Subject: Fao Lucy Taylor planning officer2023/93162

North West (Rear) Elevation

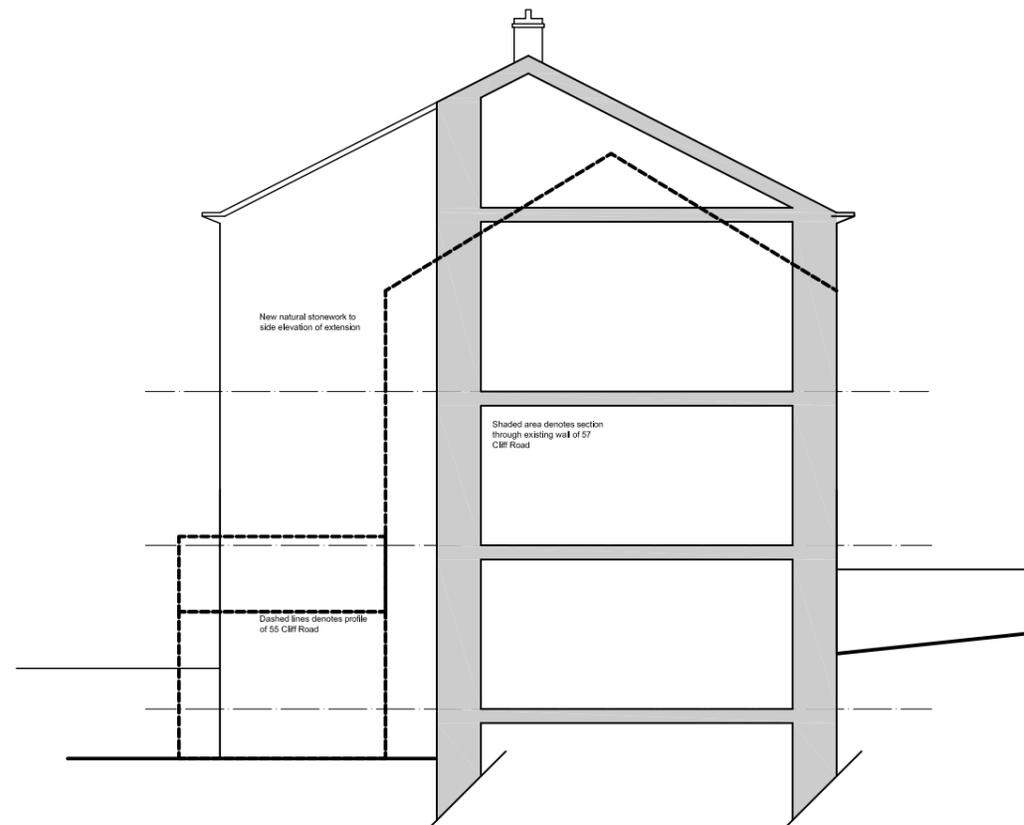
Re plan - the NW elevation 1018098 showing 2 cars parked at the rear is complete wishful thinking. The plan says 2 existing spaces but there is only room for 1 car. The 'lip' of the retaining wall garden down hill needs to be raised as it is a steep drop
